SD1.0
Site Development
Plan
Scale
1" = 20'-0"

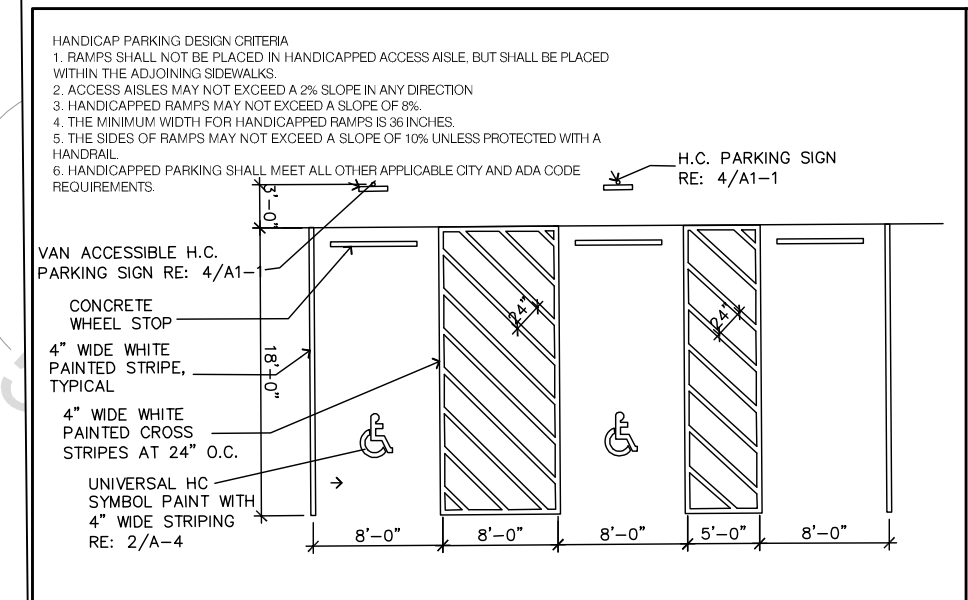
Show parking detail on site development plan
Show ADA route

The following note should be added to all site development plans or non-residential site plans, as applicable, prior to PCD approval:
The parties responsible for this plan have familiarized themselves with all current accessibility criteria and specifications and the proposed plan reflects all site elements required by the applicable ADA design standards and guidelines as published by the United States Department of Justice. Approval of this plan by El Paso County does not assure compliance with the ADA or any regulations or guidelines enacted or promulgated under or with respect to such laws.

Show this measurement

Add PCD File # to all pages

Should show entire lot and indicate where close up is located
